CITY OF ALBUQUERQUE

Re: Hastings, 840 Juan Tabo Blvd. NE, (K-22/D035C)
Approval of Permanent Certificate of Occupancy (C.O.)
Engineer's Stamp Date 08-15-2007,
Certification dated 8/31/07

**Re: Hastings at Lomas and Juan Tabo, Grading and Drainage Plan
Engineer's Stamp dated 7-27-06 (K22-D35C)**

**Re: Hastings Grading and Drainage Plan
Engineer's Stamp dated 6-9-06 (K22/D35C)**

GRADING & DRAINAGE PLAN

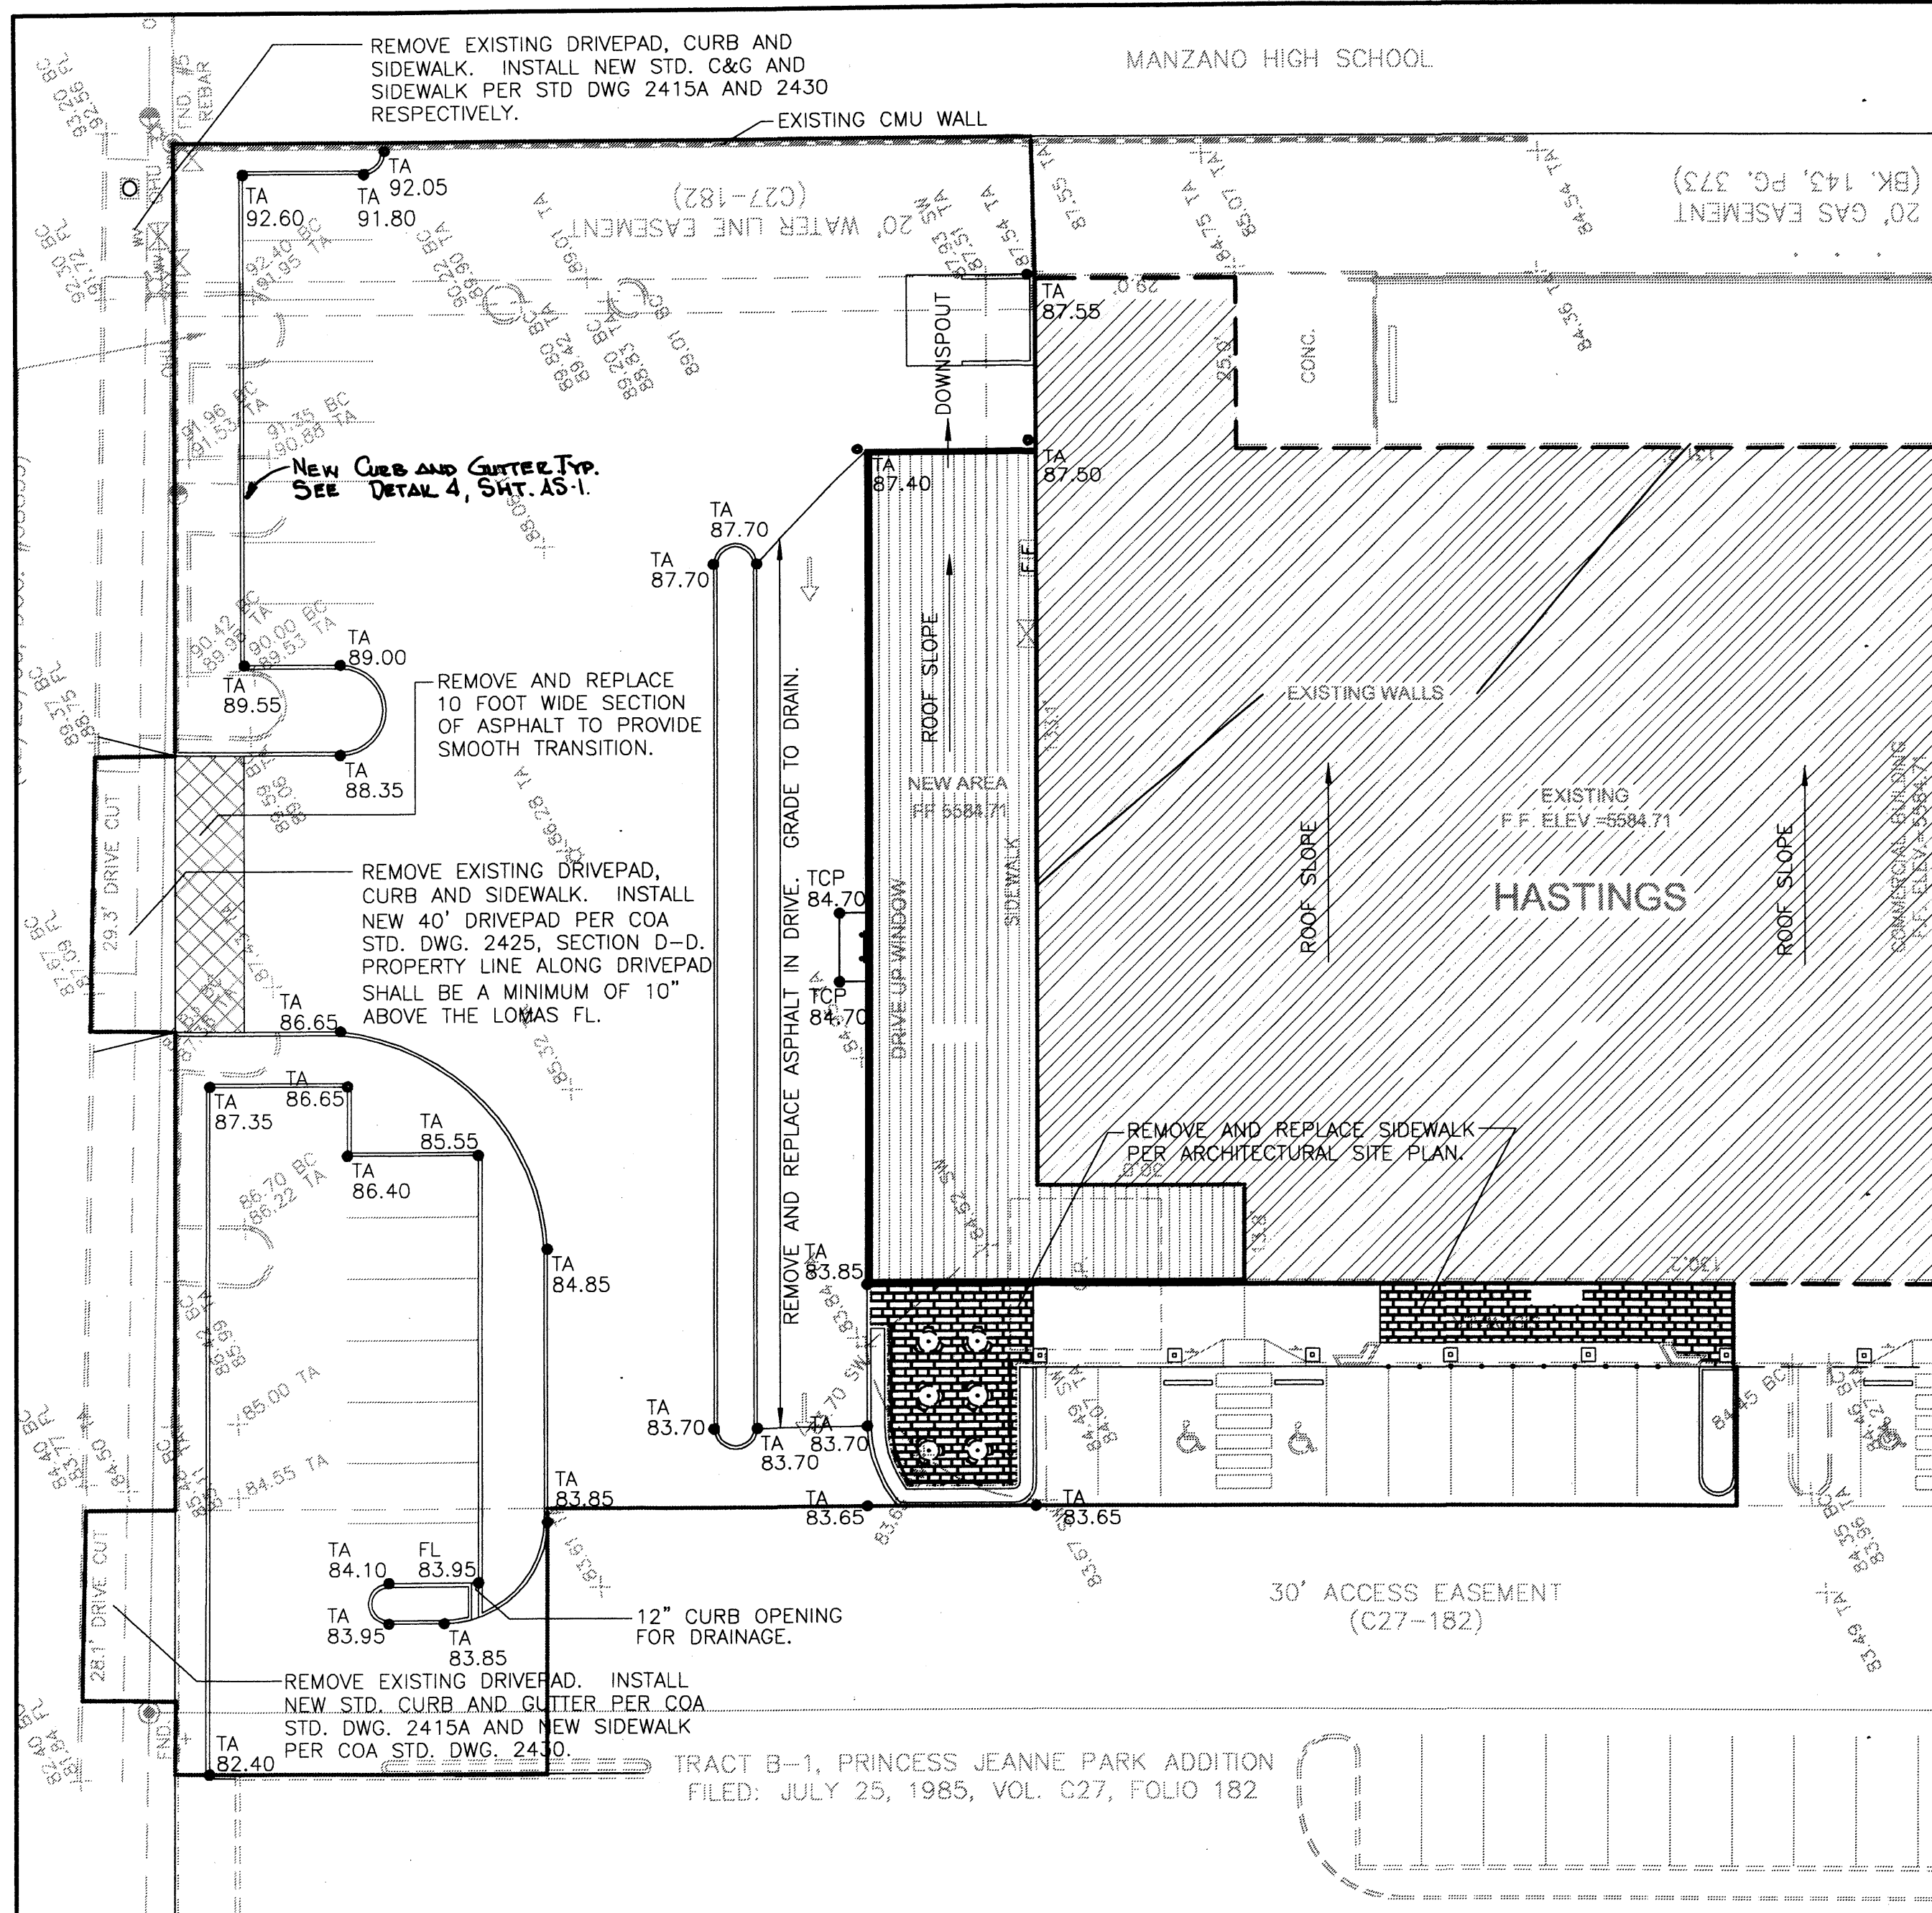
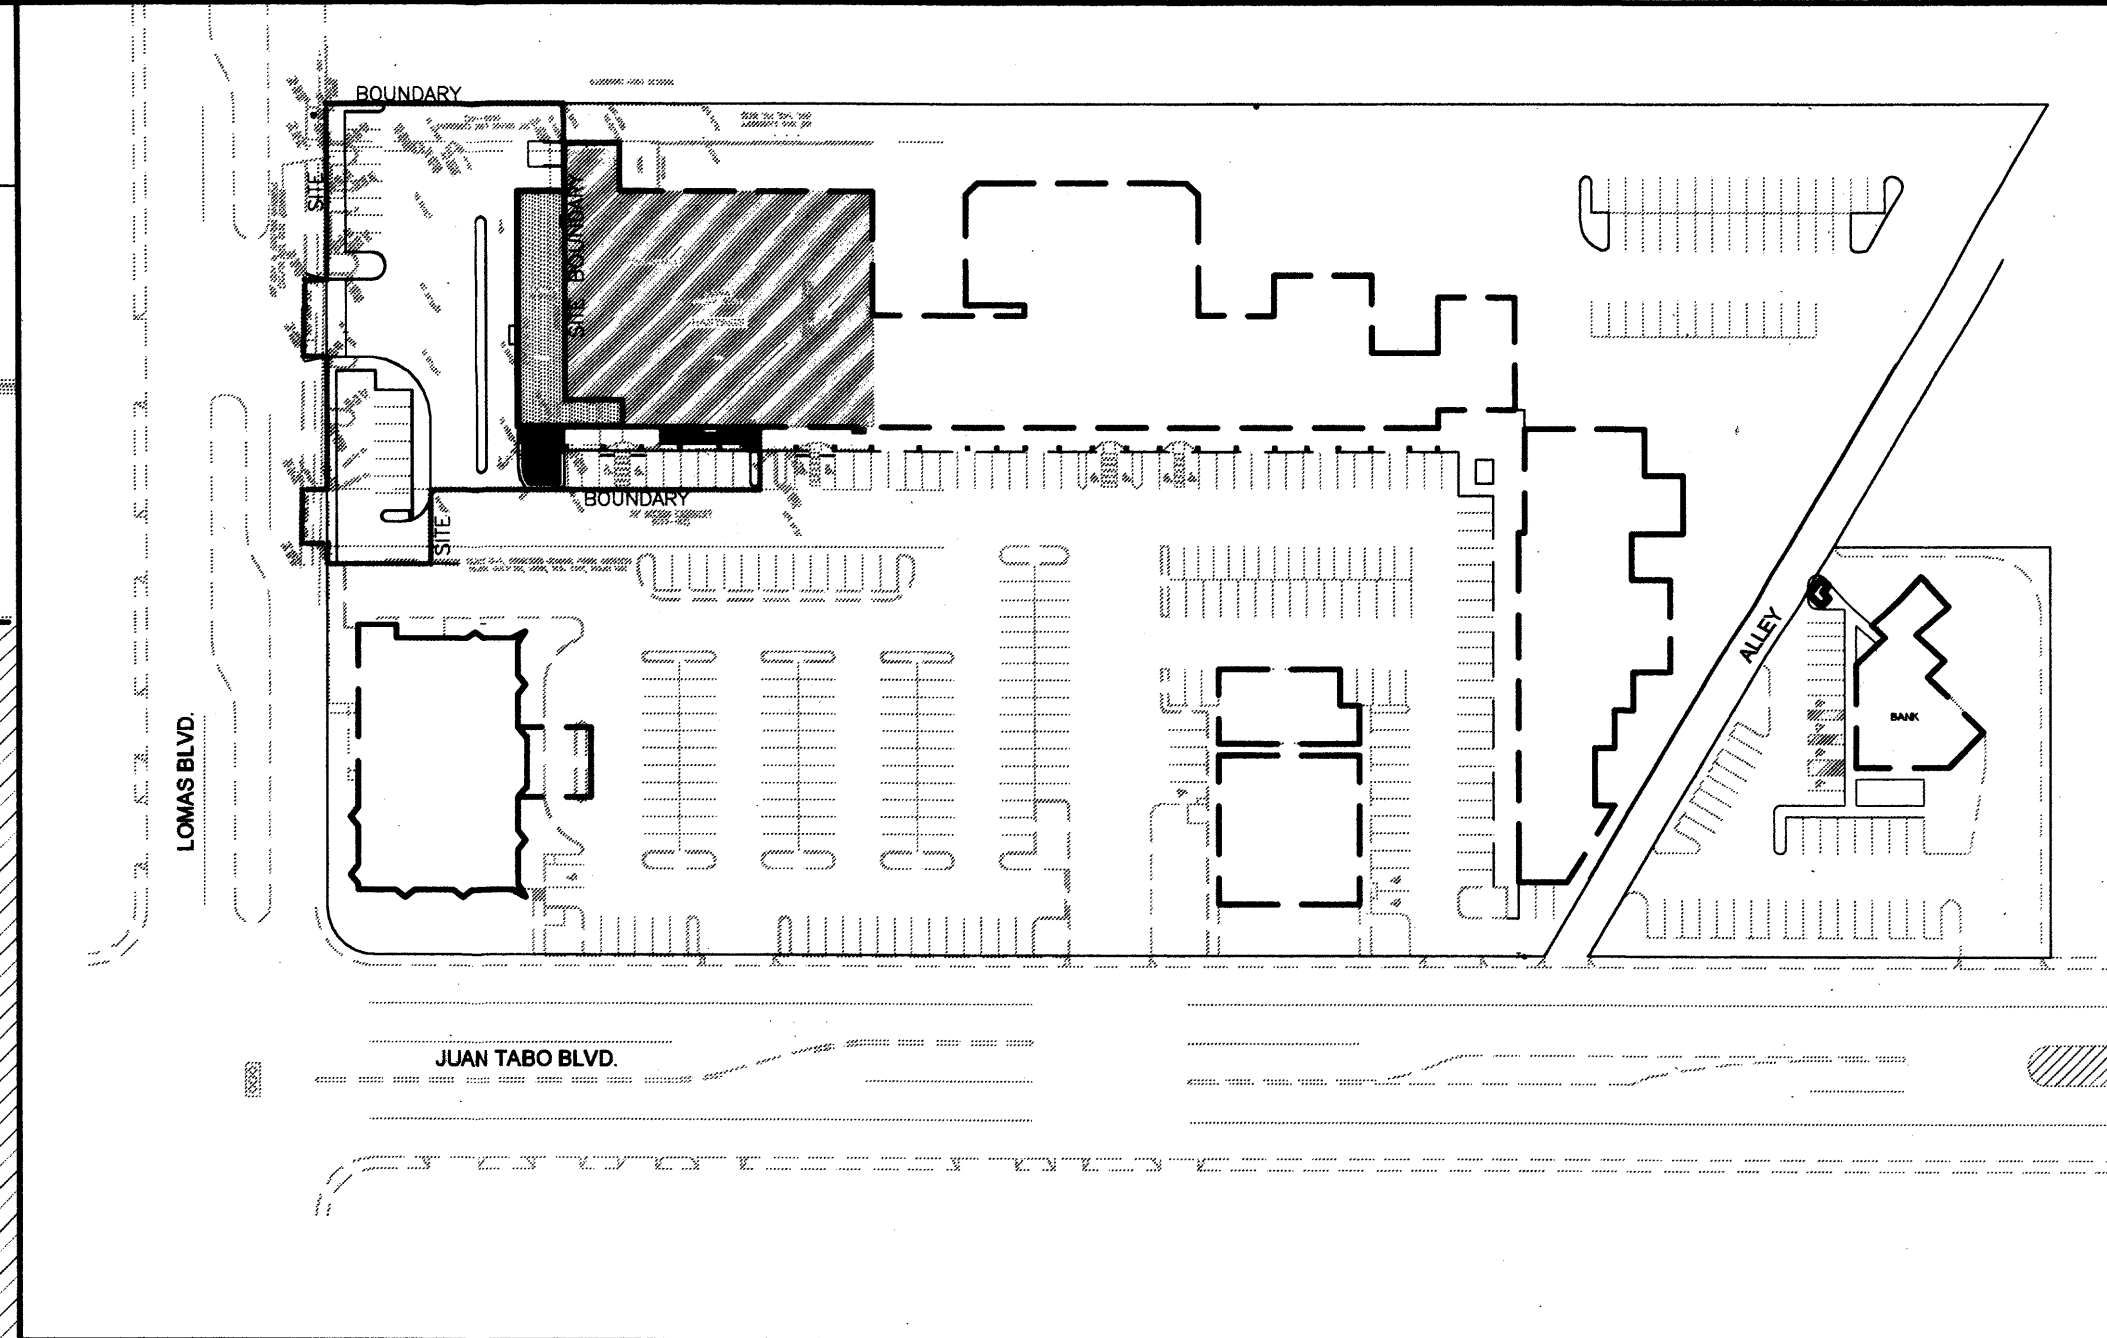
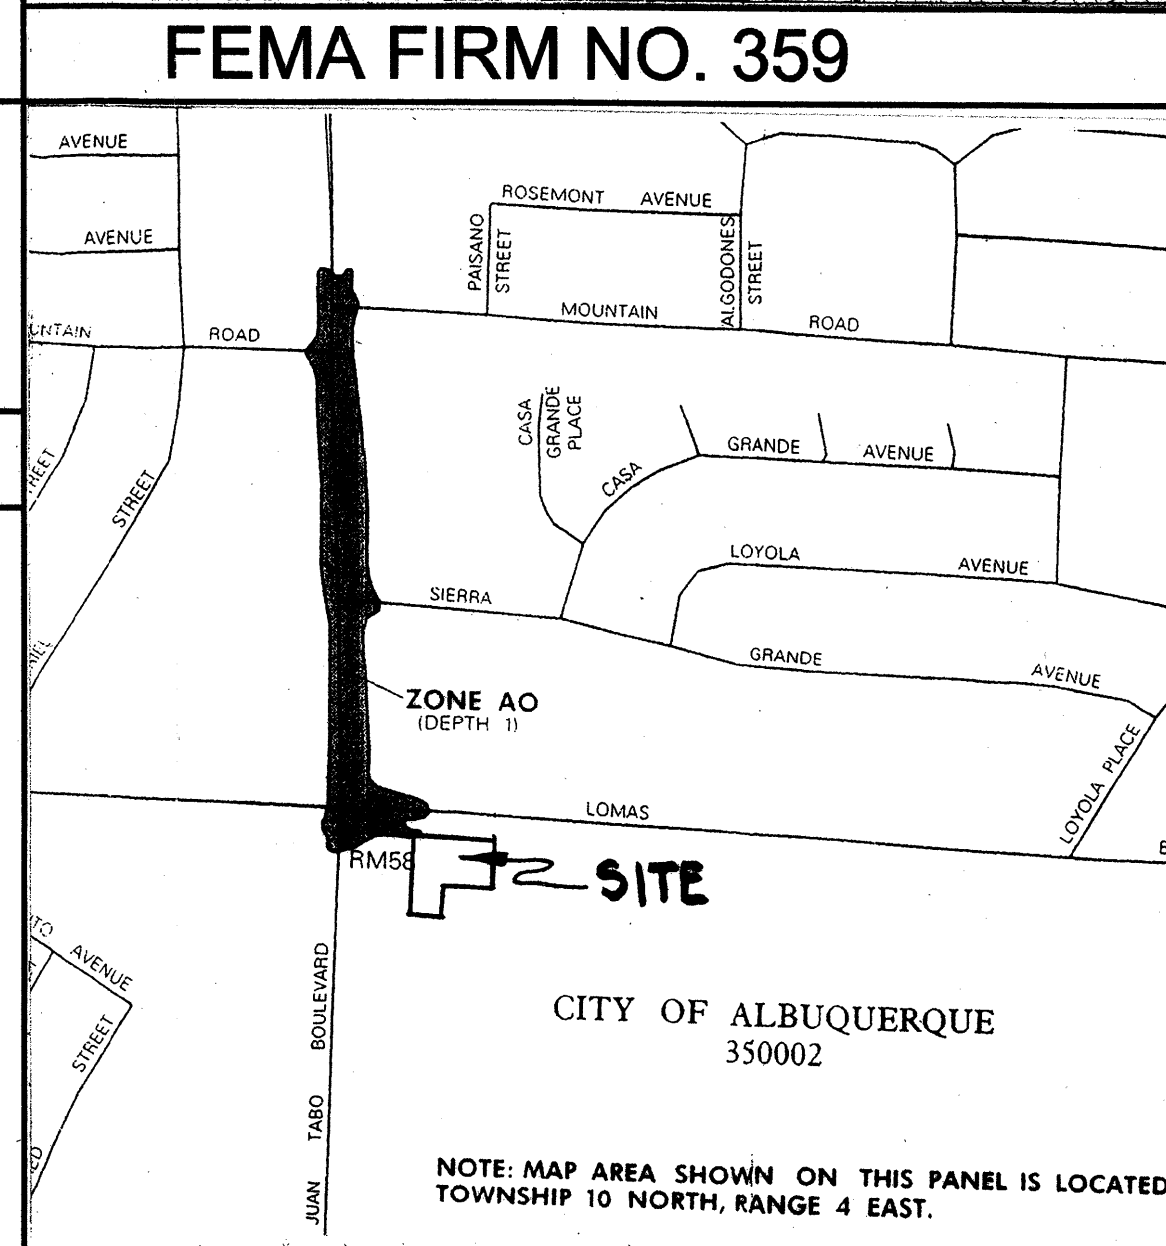
Based upon the information provided in your submittal dated 6-12-06, the above referenced plan cannot be approved for Building Permit until the following comments are addressed:

- Since the finished floor elevation is lower than the street flow line, provide a water block in the drive pad.
- Two spot elevations just west of the drive, 83.65, appear to be typographical errors.
